CITY OF ALBUQUERQUE

**Re: Chaparral E.S., Parent Parking Lot
Grading and Drainage Plan, 3625 Milne Rd. NW
Engineer's Stamp dated 09-18-2013 (F-10/D005)**

Based upon the information provided in your submittal dated 09-19-13, the above referenced Grading and Drainage plan cannot be approved for building permit based on the following comments:

OVERALL GRADING & DRAINAGE PLAN

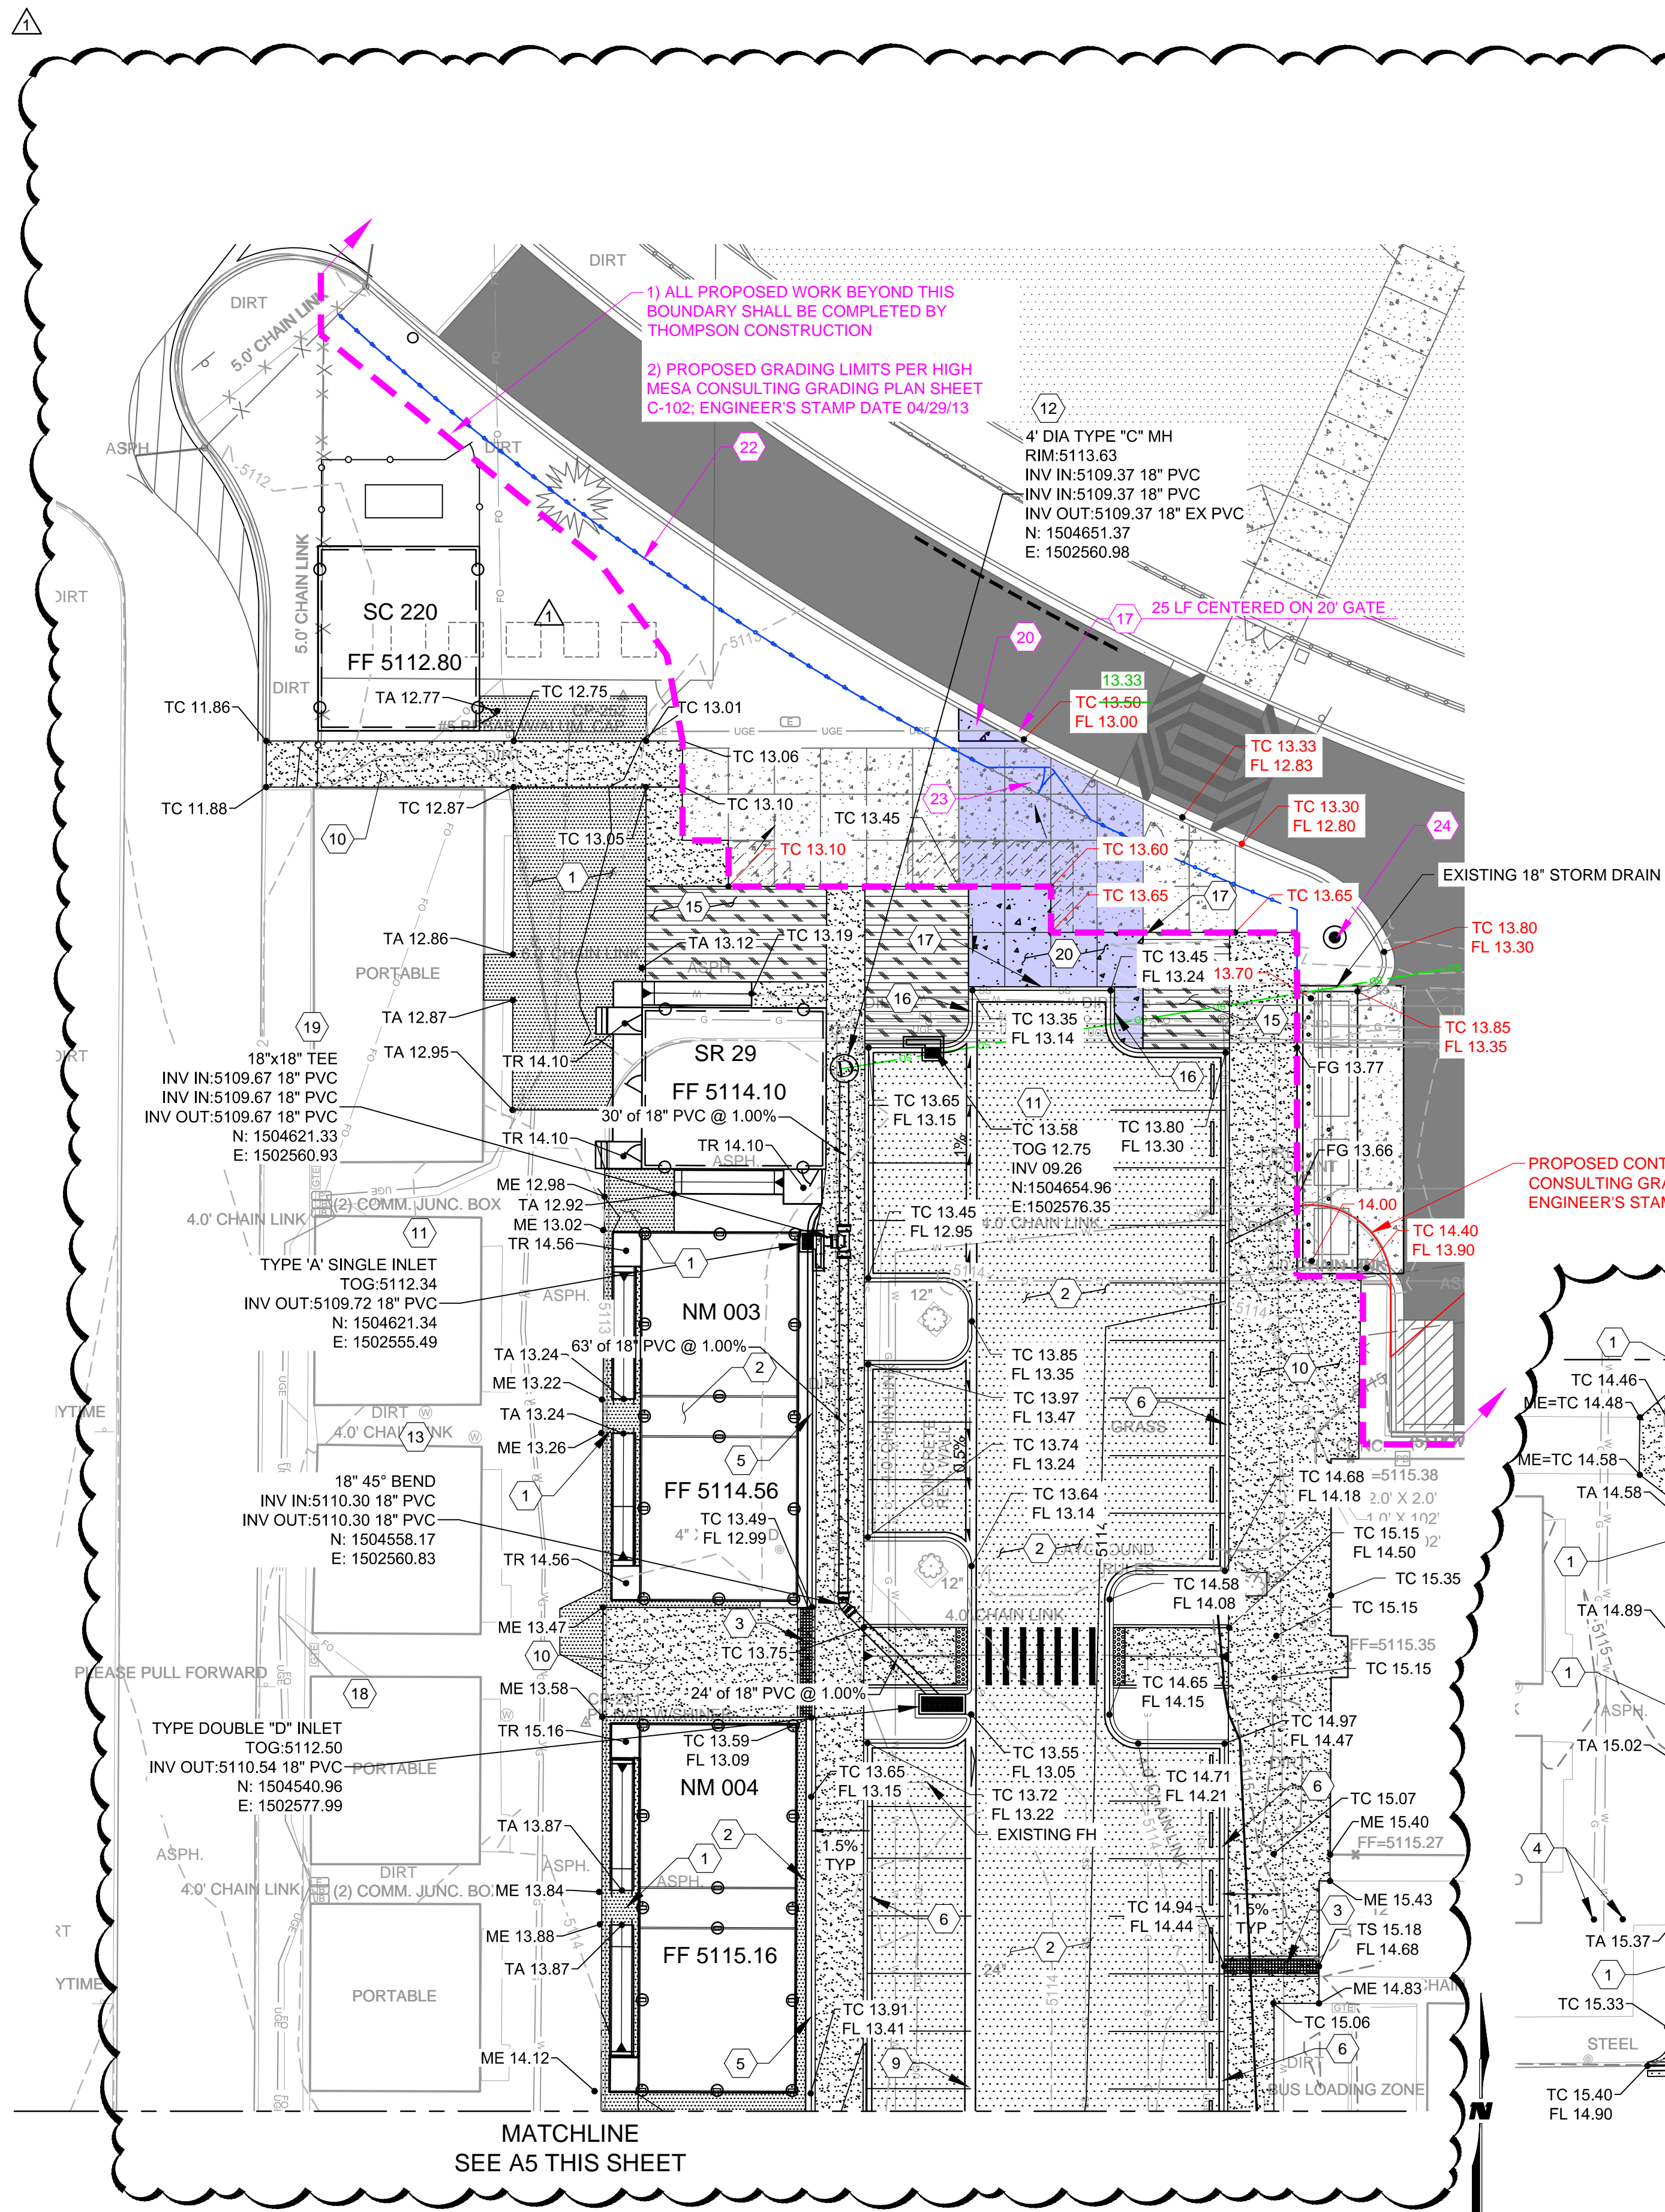
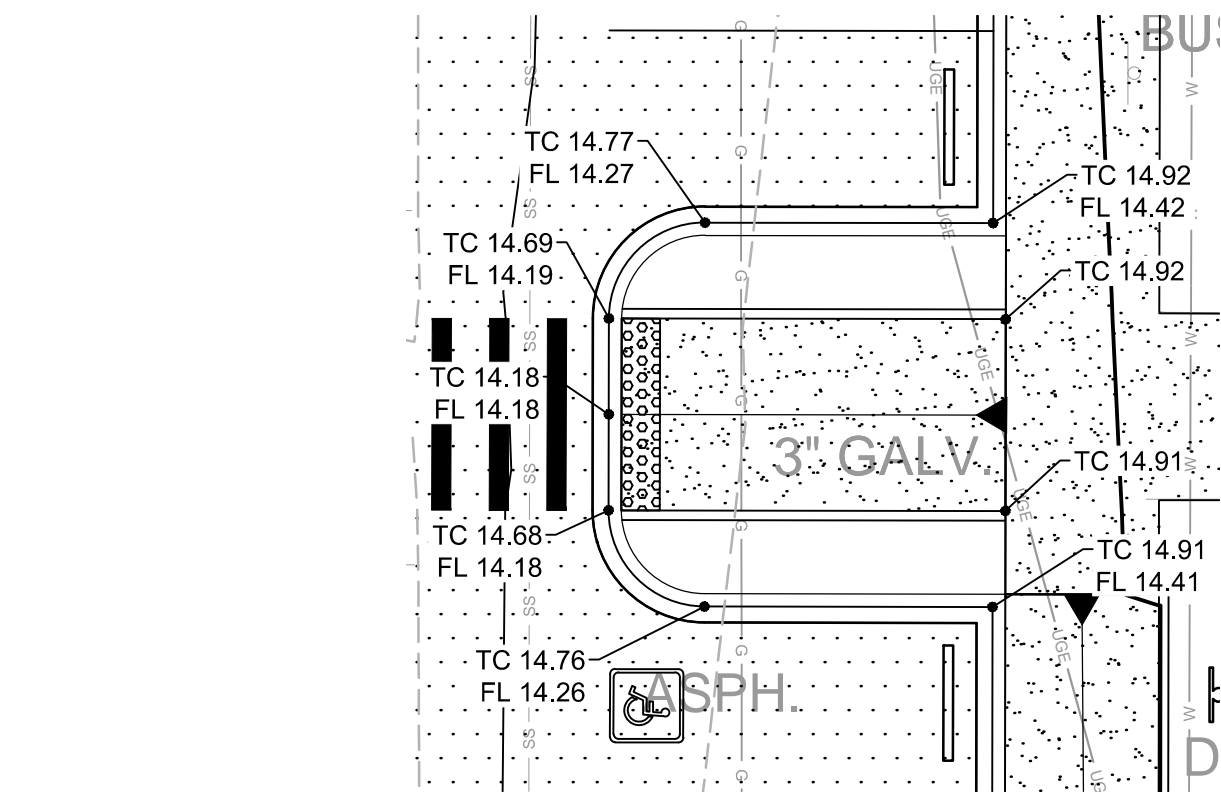
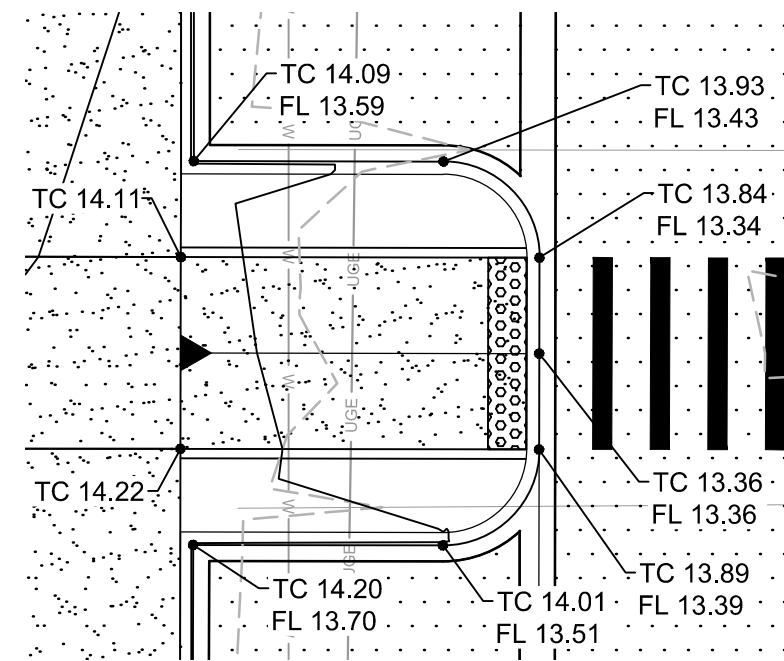
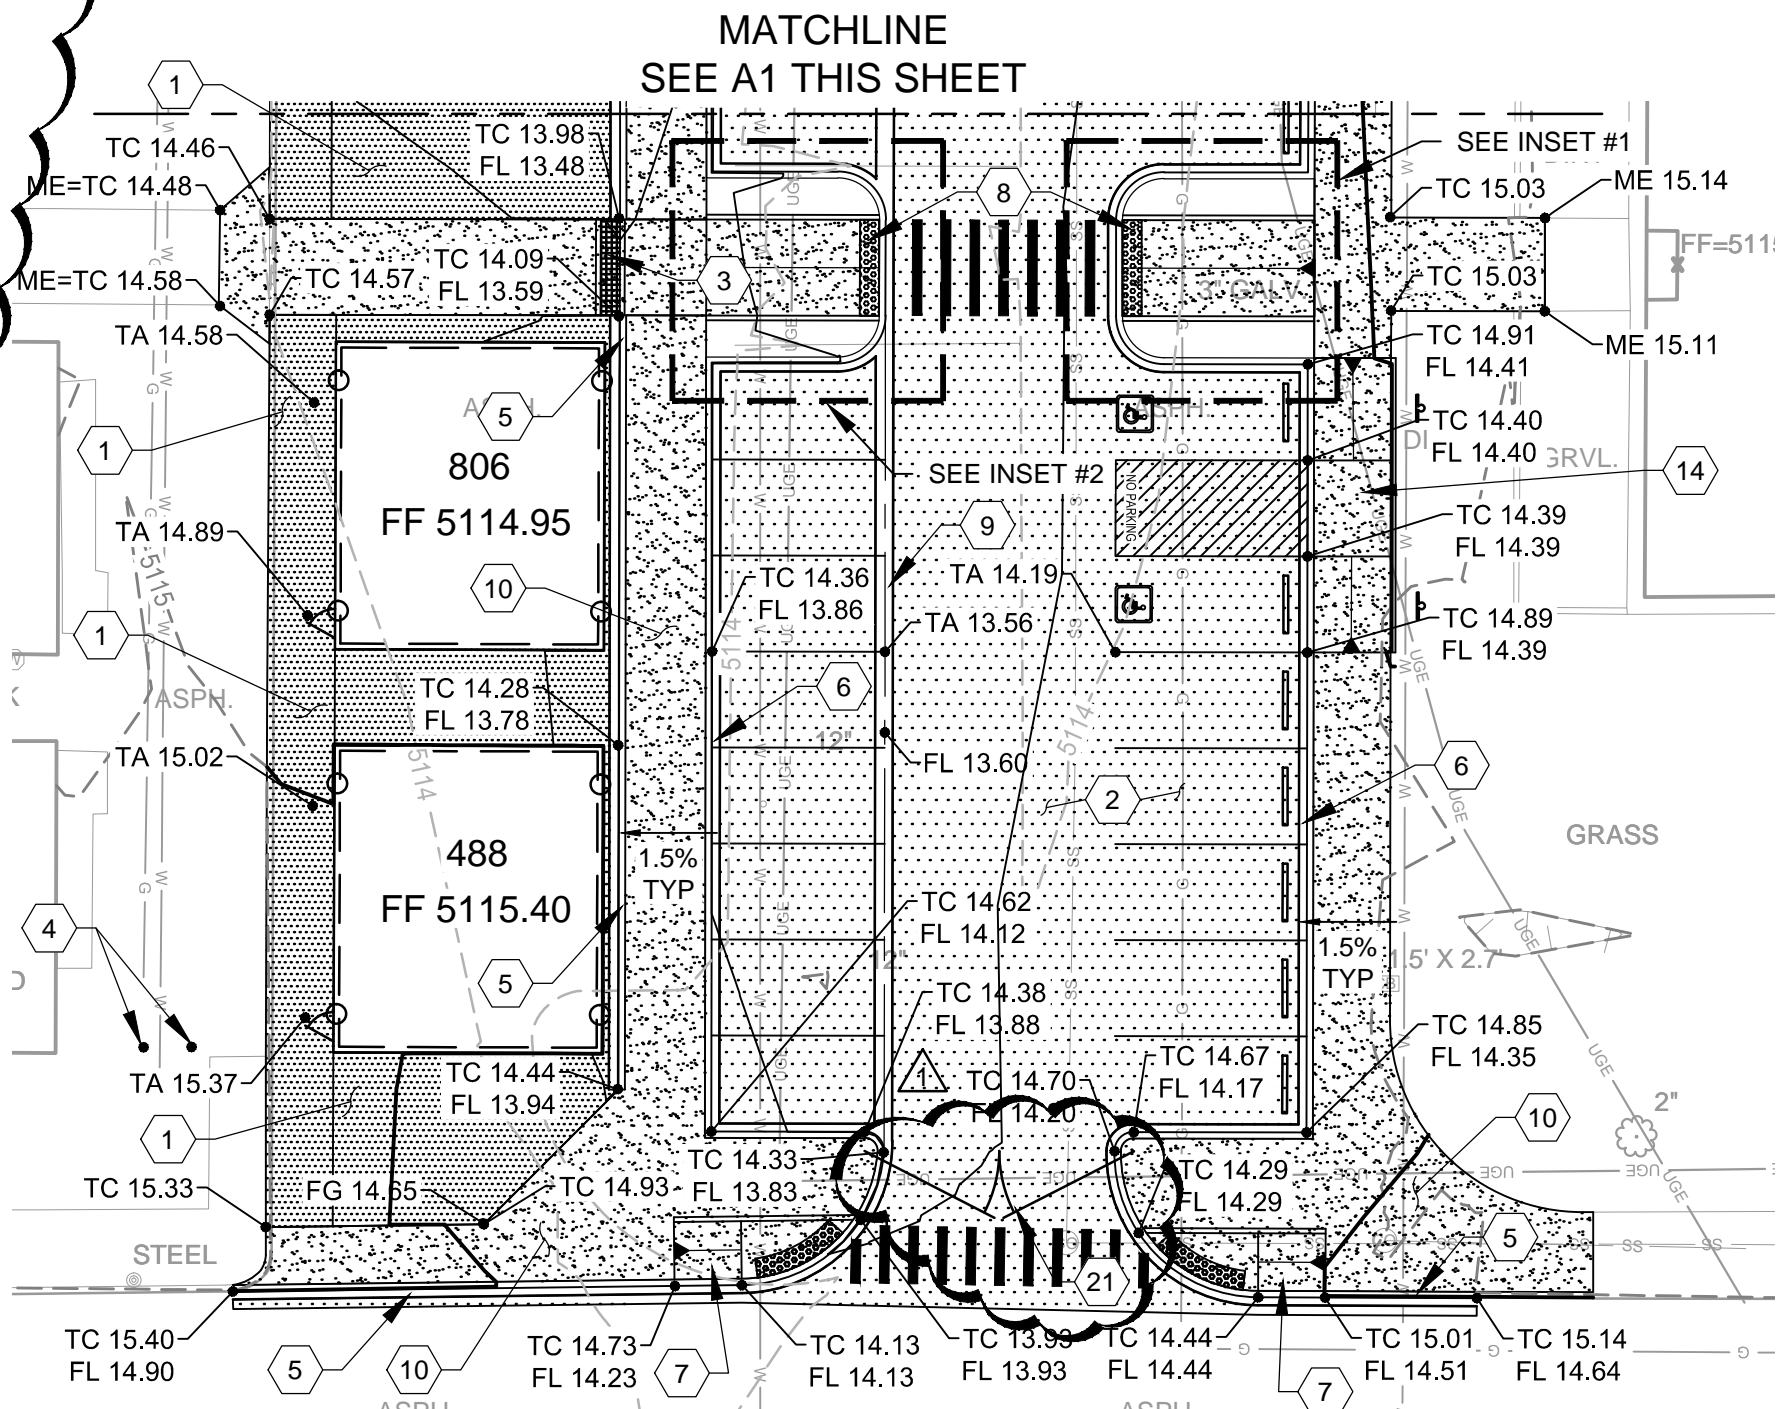
- Provide capacity calculation for the Beehive Grate. Please use a 50% clogging factor in your calculations. The grate may have to be lowered to avoid overflow.
- Modify the grading plan if the Beehive Grate must be lowered.
